2023/0087

Erection of a two-storey side and single storey front and rear extensions

19 Cropton Road, Royston, Barnsley, S71 4JJ

Drawing Title
PROPOSED ELEVATIONS

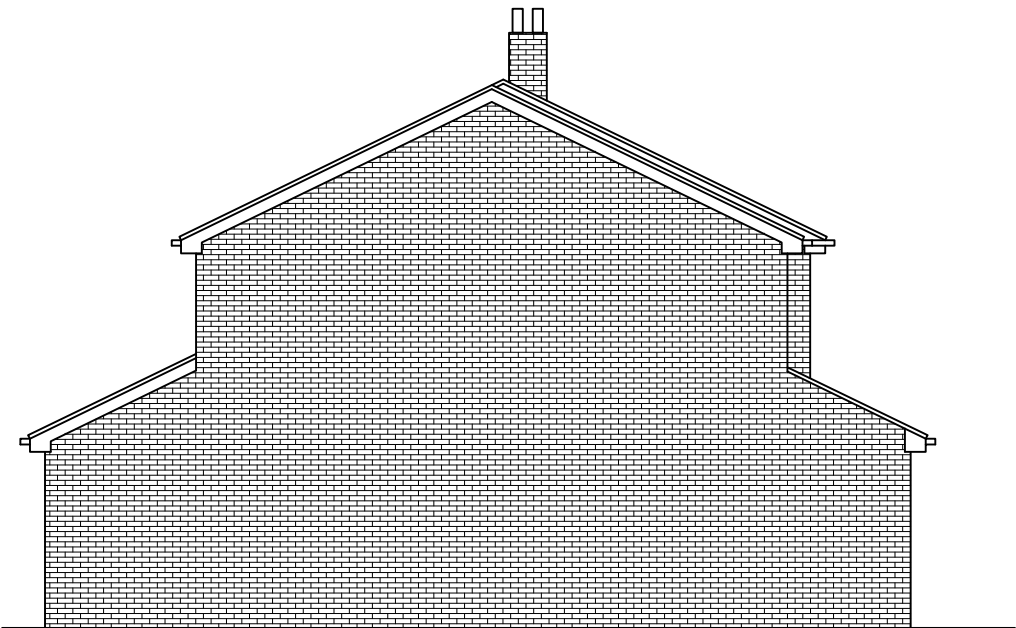
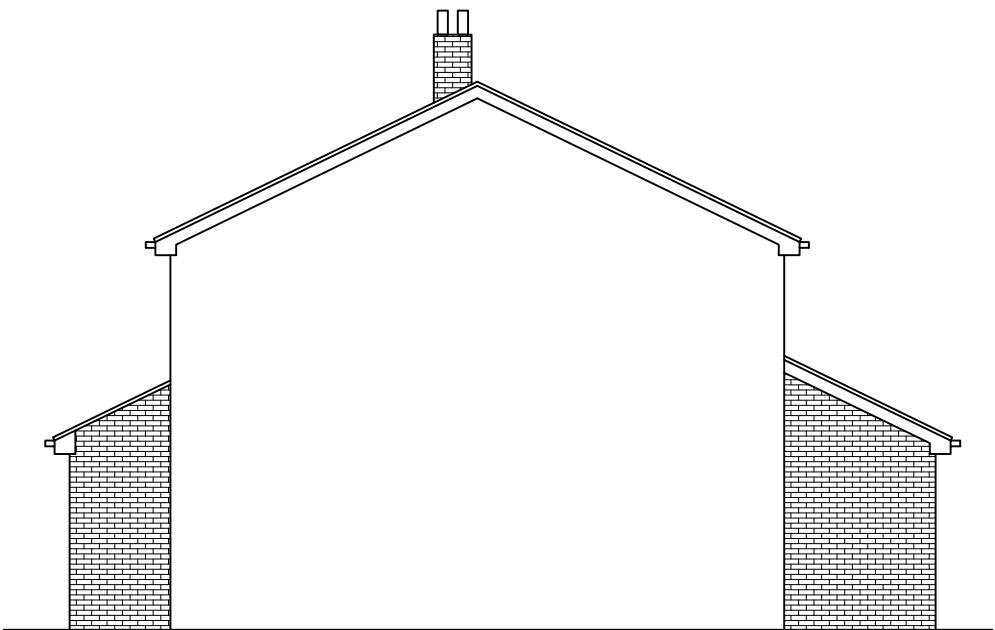
The Supplementary Planning Document - House Extensions and other Domestic Alterations states that 'the design of a two-storey side extension should reflect the design of the existing dwelling in terms of roof style, pitch materials and detailing and should not have an excessive sideways projection, i.e., more than 2/3 the width of the original dwelling'. In this instance the proposed extension projects 2.6m from the side elevation and therefore complies with the guidance set out in the SPD.

The document also states that a two-storey side extension should have a set back from the front elevation, to allow for a vertical break in the roof plane, a lowering of the ridge line and to reduce the terracing effect. The set-back also lessens the unsightly bonding of old and new materials; the proposal allows for a set-back of 300mm and allows for a corresponding lowering of the ridge line therefore complying with the SPD.

The front elevation is the most important for its contribution to the street scene; the proposed front extension is to link in with the existing single storey forward projection and sees the introduction of a door to the front elevation, providing an active frontage to the dwelling.

The extensions are designed to harmonise with the original dwelling in terms of roof style and pitch, and fenestration, in addition they are to be constructed from materials which match the original dwelling. Therefore, it is considered that the proposed extension is acceptable in terms of visual amenity and in compliance with Local Plan Policy D1: High Quality Design and Place Making.

Drawing Title
CONSTRUCTION PLANS

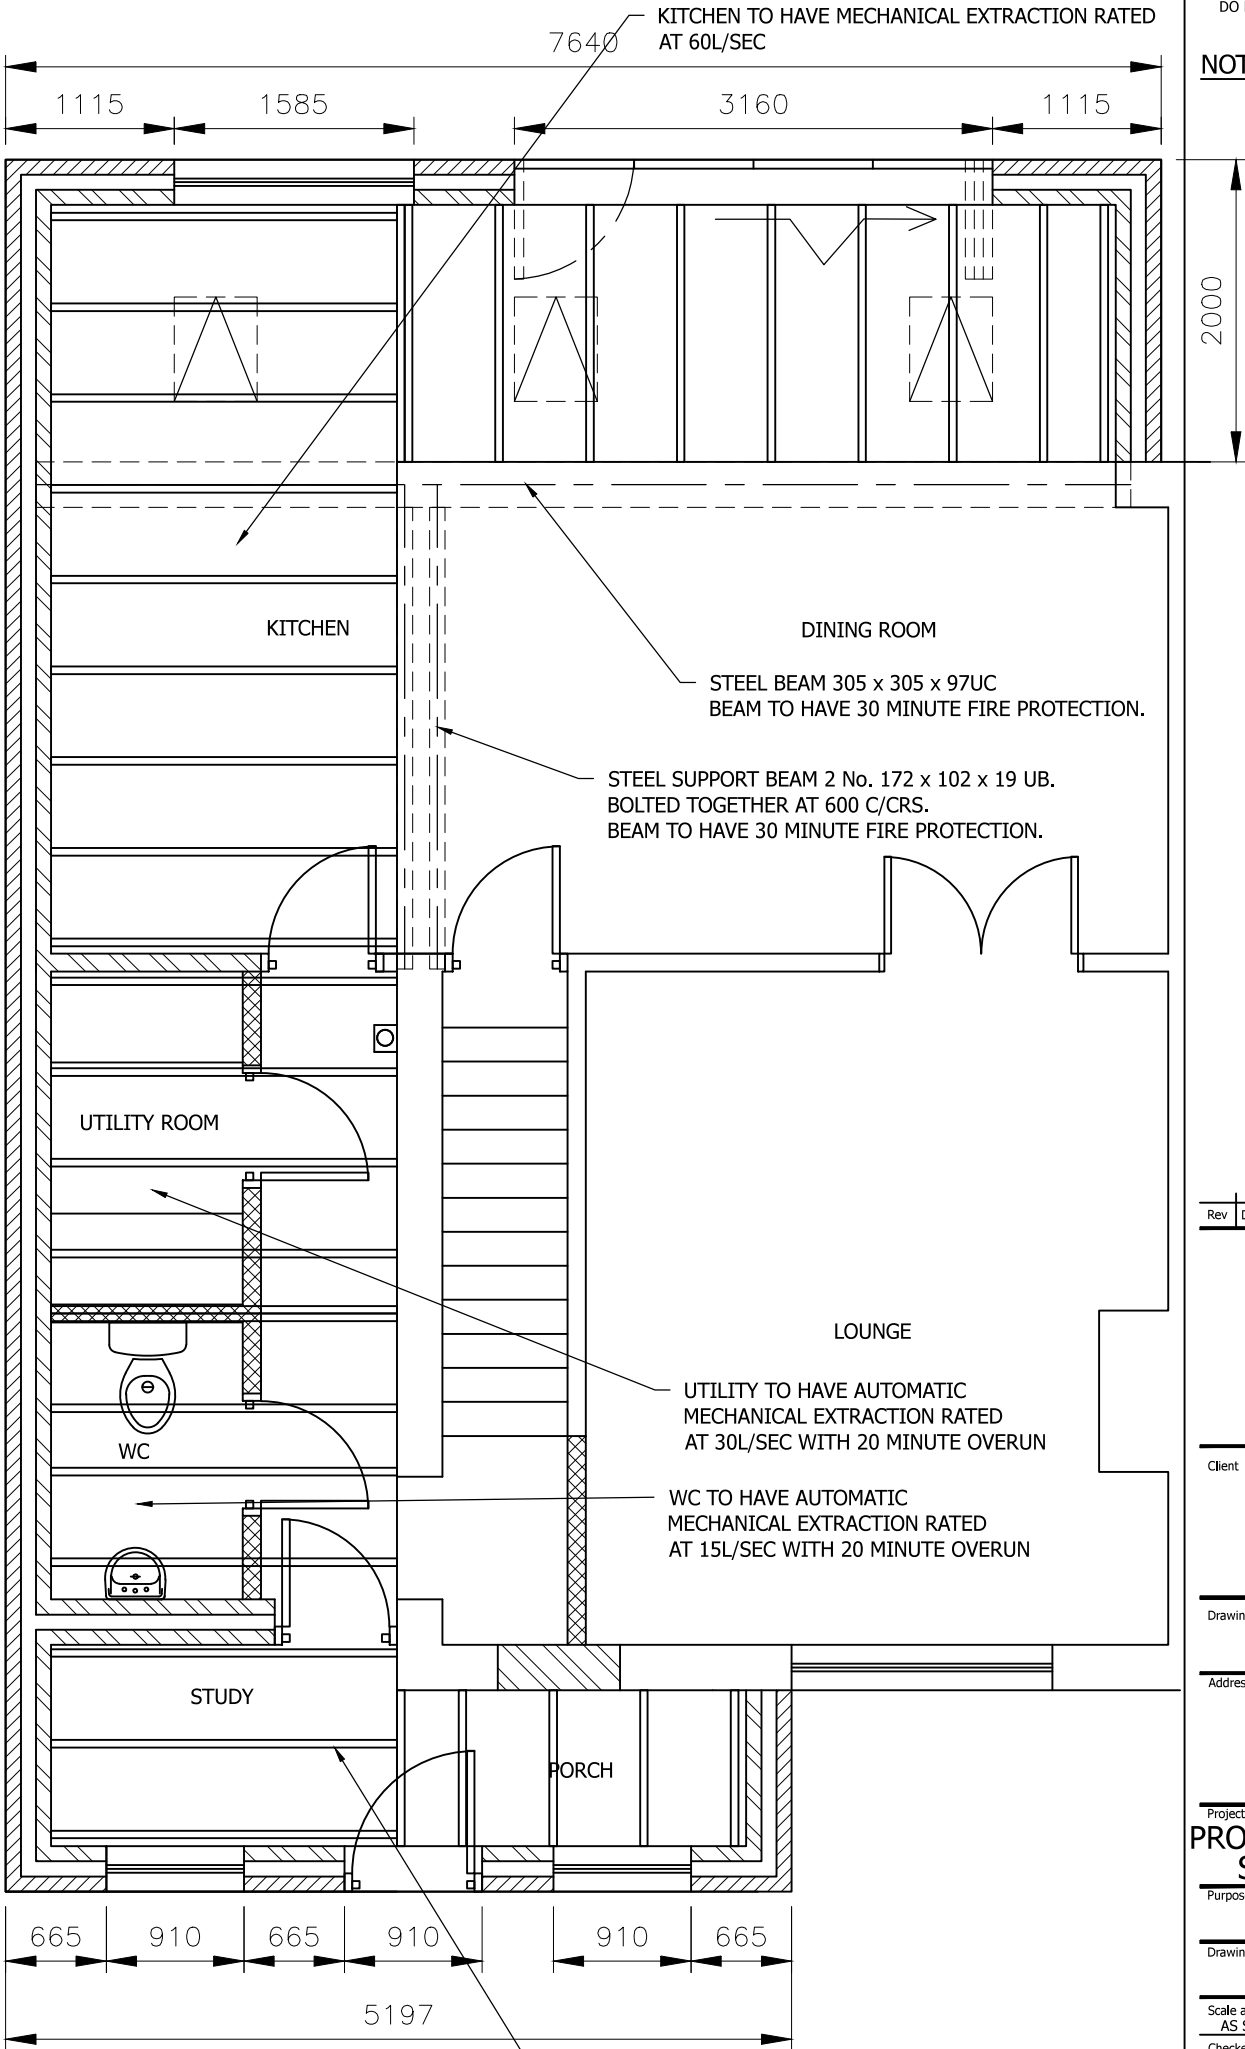
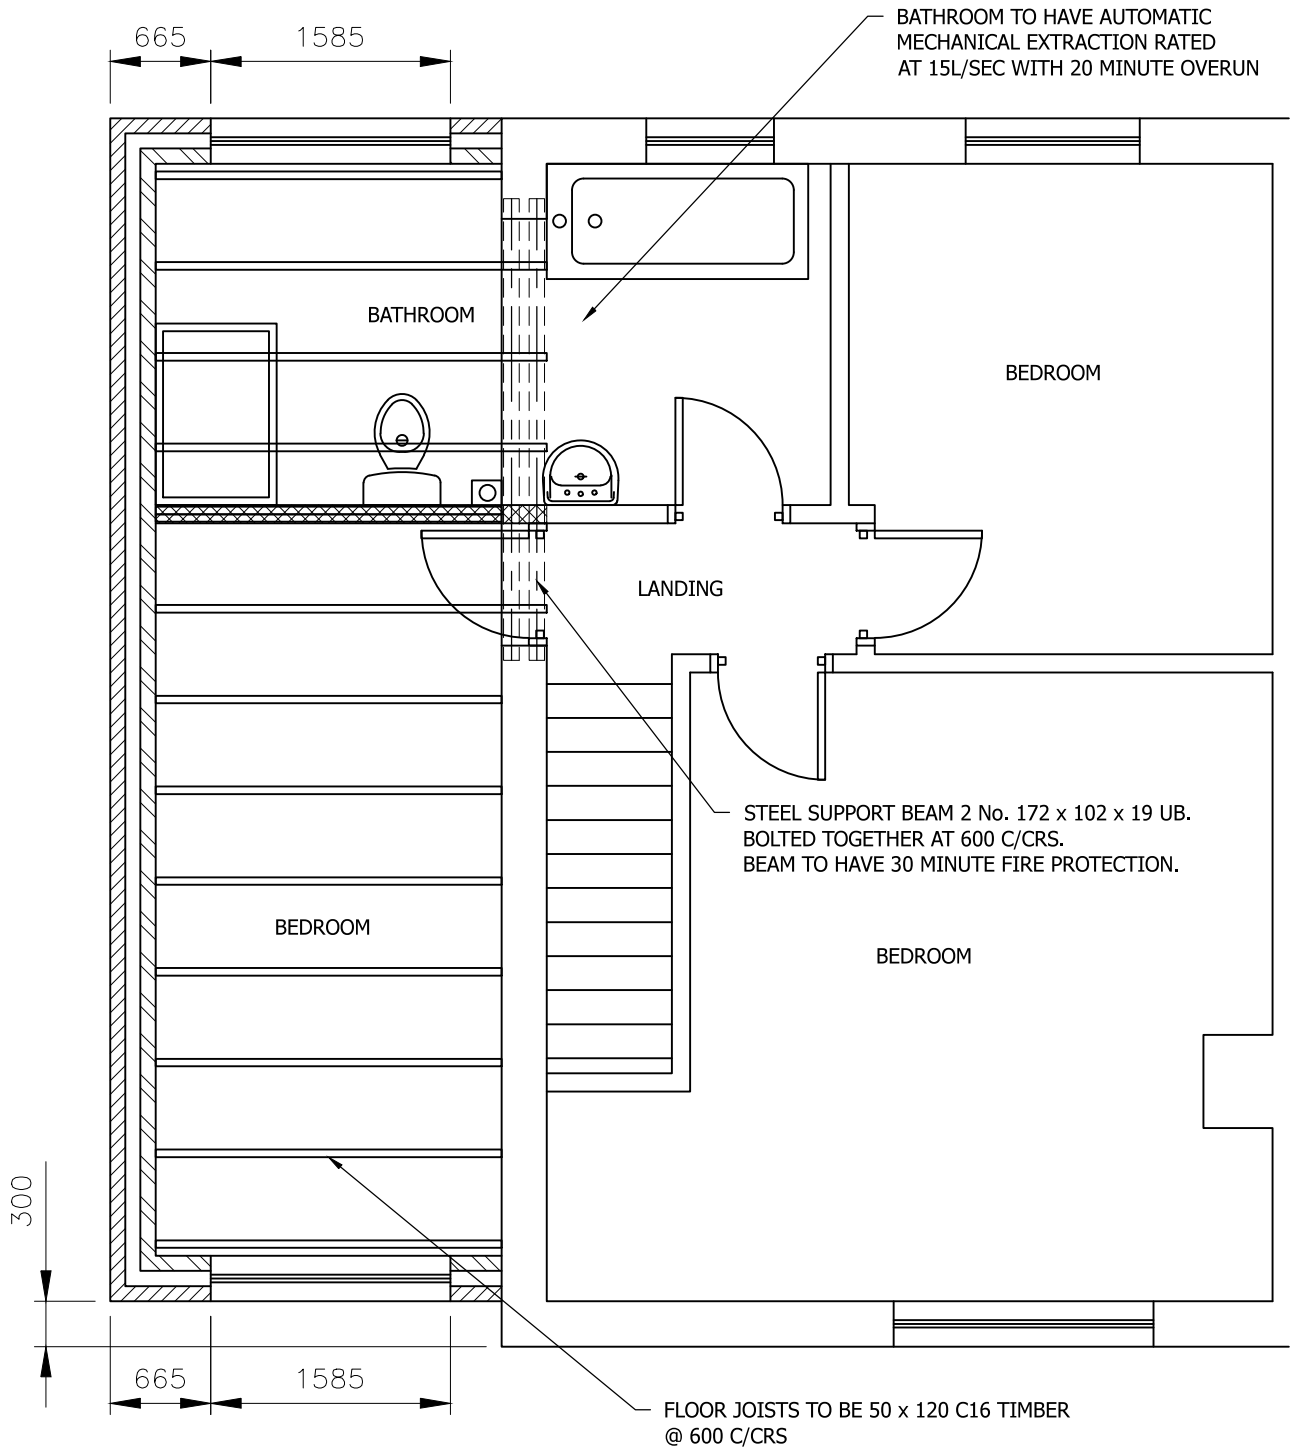
Supplementary Planning Document – House Extensions and other Domestic Alterations states that single storey extensions to the rear of semi-detached dwellings should not project more than 4m and that the eaves height should not exceed 2.5m where the extension would project beyond 3m.

The proposed extension is to project 2m from the rear elevation and therefore falls within the principles set out in the SPD; in addition, the rear extension, whilst requiring planning permission, falls mainly within the parameters of permitted development as set out in the Town and Country Planning (General Permitted Development Order) 2015 (as amended). The neighbours have not objected to the proposal, and as the impact to the adjoining neighbour will be similar to that allowed under permitted development, the rear extension is considered acceptable.

Neither the proposed side or rear extensions include windows along the side elevation facing the neighbouring properties, and those located at first floor do not extend closer to the rear boundary than the existing dwelling, with the existing boundary treatment providing suitable screening from the windows at ground floor level.

SITE PLANS

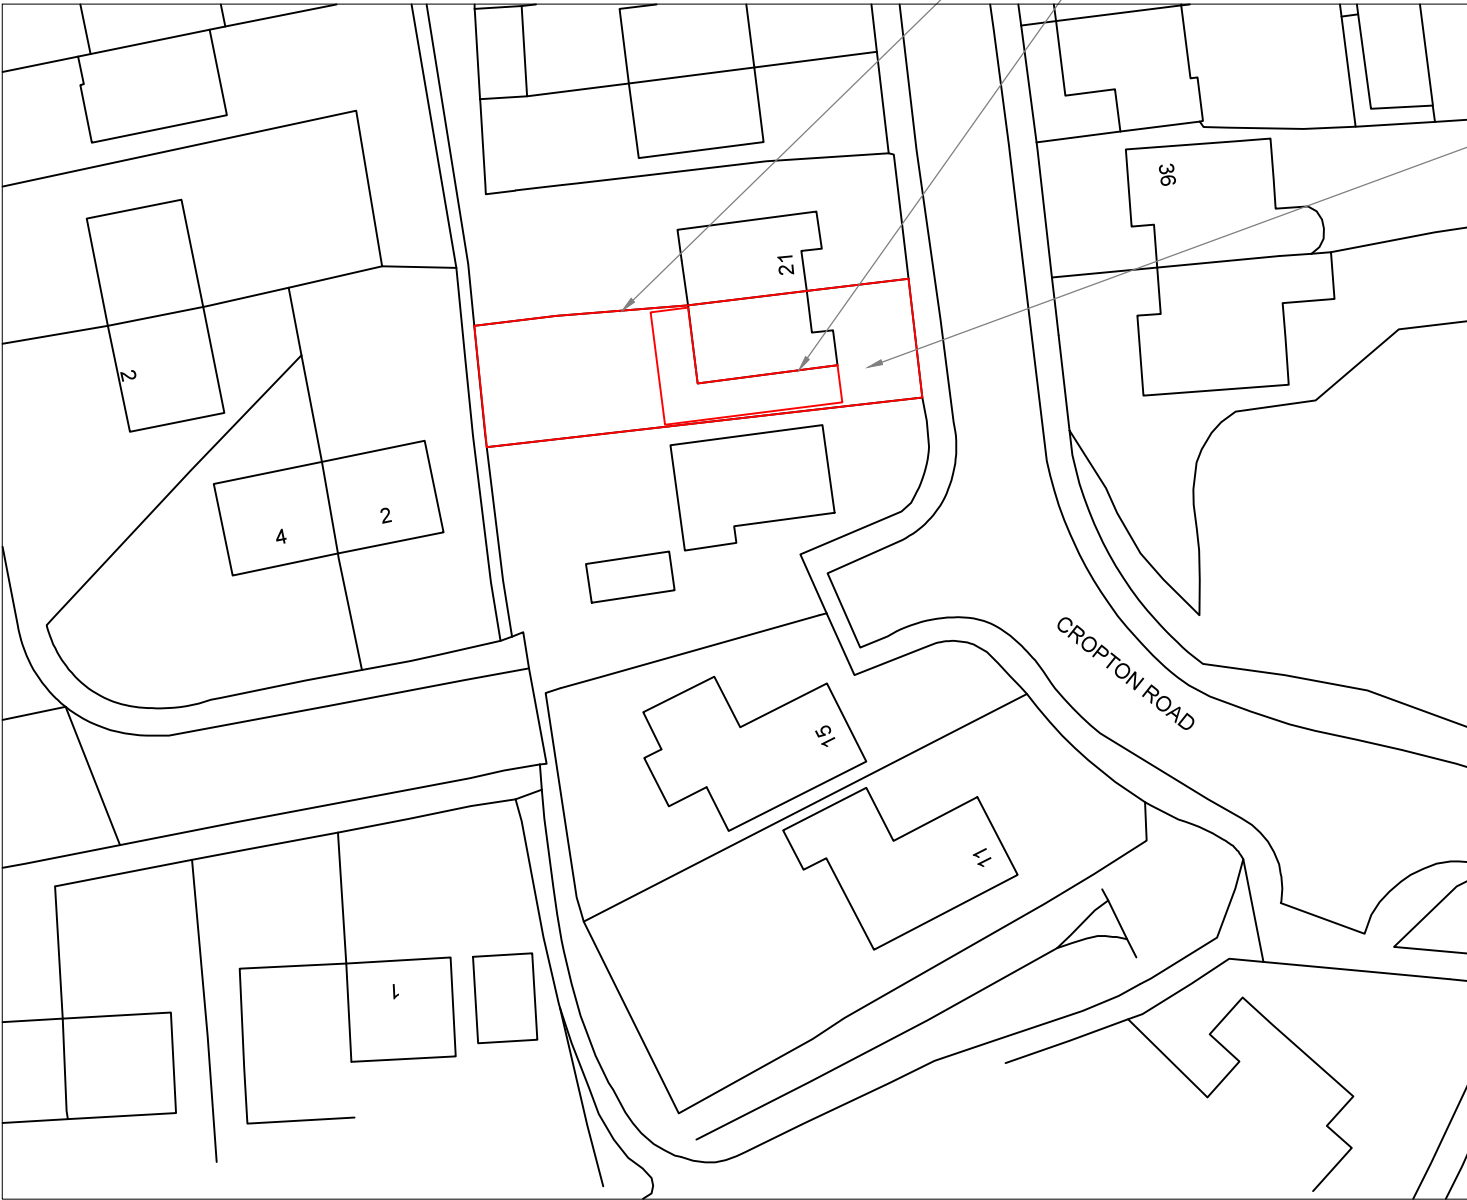
The proposal would result in the loss of off-street parking in addition to the requirement of additional provision. Whilst the driveway length is reduced to 5.5m, there is sufficient space to the front of the property to accommodate space for 2no vehicles. In addition, an extension on this footprint could be erected under permitted development which would see the loss of parking provision; the dwelling is located within a residential housing estate and not on a busy highway and therefore it is considered that the extension would not impact on highway safety and as such is acceptable and in compliance with Local Plan Policy T4.
